Rezoning Transportation Analysis

Petition Number: #2021-120

General Location Identifier: 09503403

Revised Site Plan 11.14.22

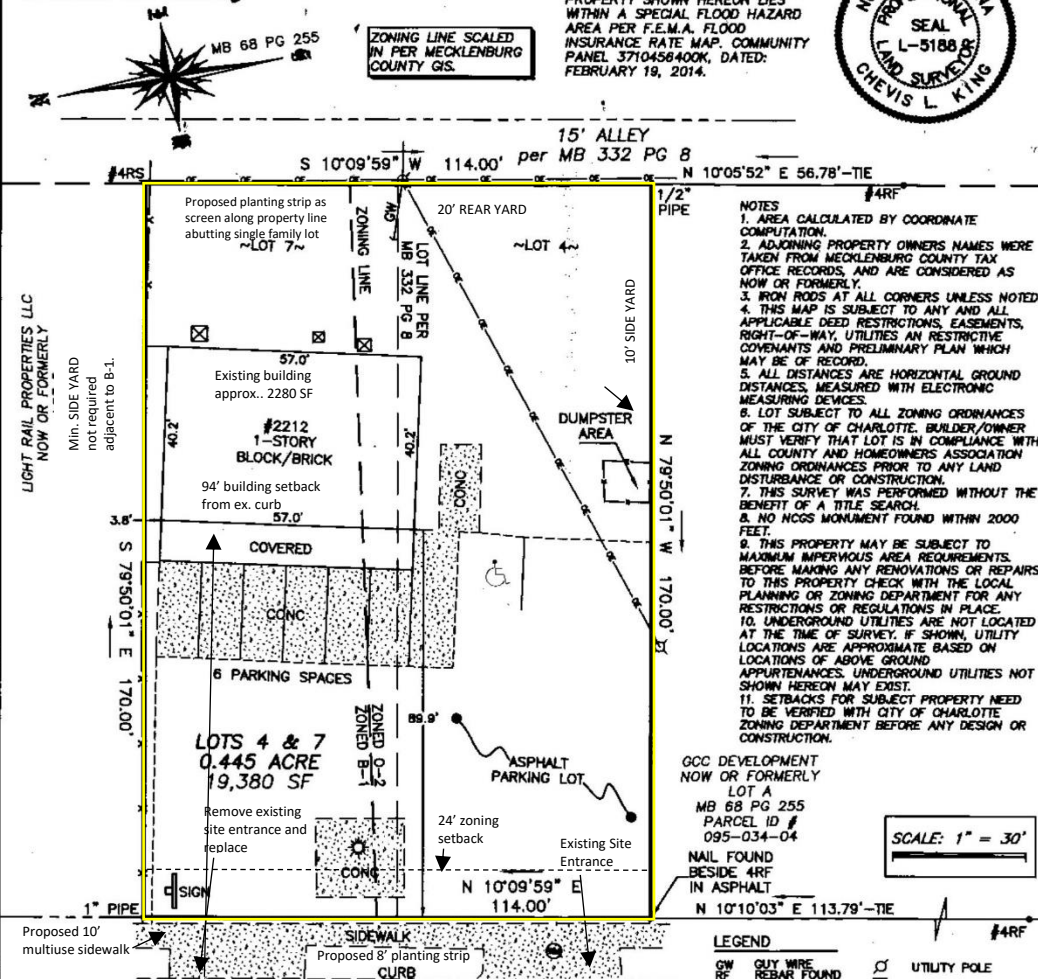
8. **New Comment from 11-28-22:** ~~Revise conditional note saying "Removal of second driveway if needed according to CDOT ordinance for NS Zoning" to say "Close northern driveway".~~ ~~Revise callout saying "Remove existing site entrance and replace" to say "Close northern driveway".~~

ANY	- The focus is on uses that support the surrounding neighborhoods
CATED	Transportation:
ITY	- Vehicular access to Site shall be via one of the current driveways as shown on the site plan
NOT	- Removal of second driveway if needed according to CDOT ordinance for NS Zoning
ED	Architectural Standards:
OR	- Fencing/landscaping along side yard and rear yard that are adjacent to residential uses per ordinance requirements for NS Zoning

Revised Site Plan 2.13.2023

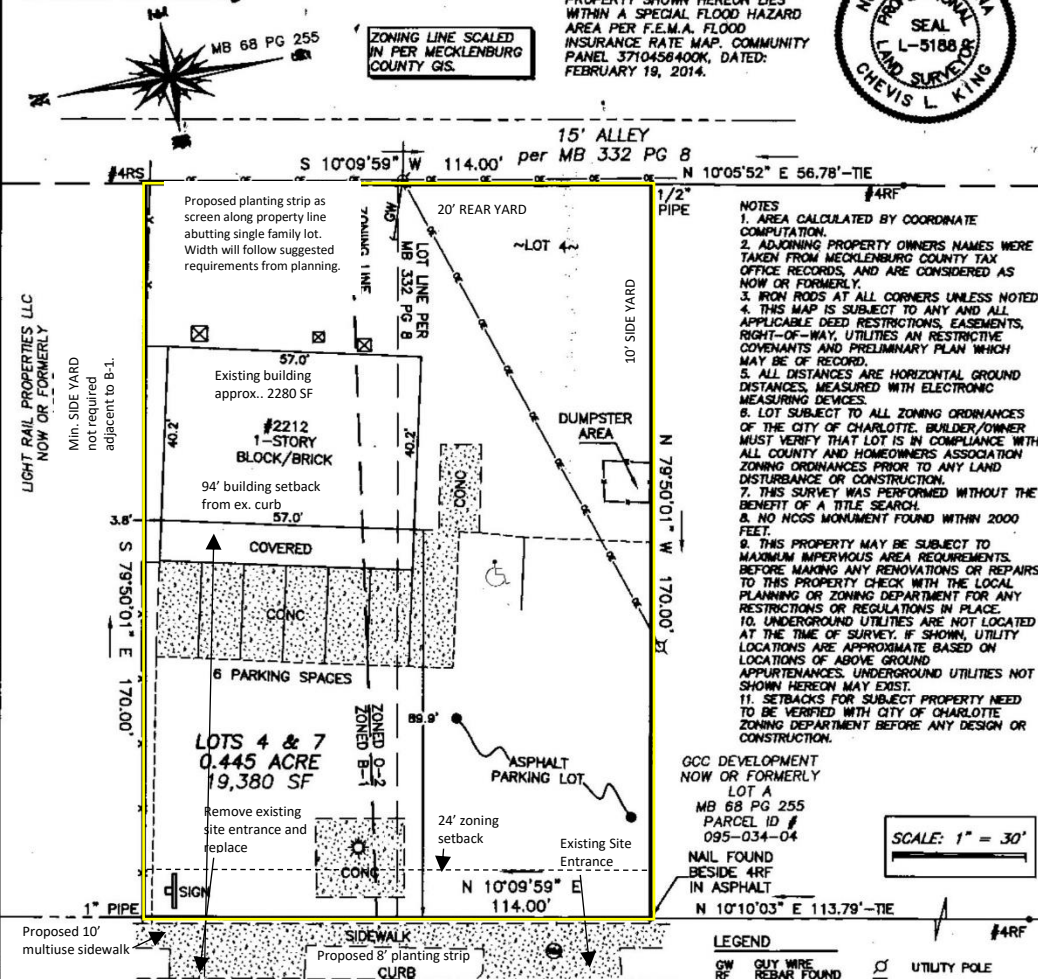
10. **Outstanding Comment from 9-28-22:** A site plan note specifying that all transportation improvements will be approved and constructed before the site's first building certificate of occupancy is issued is needed. The petitioner may phase transportation improvements if said improvements and phasing are explicitly described in site plan notes.

Comment Clarification 04-13-23: Remove "if needed" and "is needed" at the end of conditional notes shown below:

- Vehicular access to Site shall be via one of the current driveways as shown on the site plan
- Close northern driveway
- All improvements will be approved and constructed before the site's first building CO is issued **if needed**
- commit to remarking current bike lane pavement markings to a dedicated right turn lane, a bike ramp near south property line per CLDSM 10.43 to transition bicyclists from separated bike lanes to multi-use path and extending the 10-foot multi-use path to the southern property.
- Commit to striping and dedicated right turn arrow per CDOT pavement marking standards
- commit to dedicating 50-feet of right-of-way if it does not currently exist.
- fee simple conveyance of all rights-of-way to the City before the site's first building certificate of occupancy is issued **is needed**
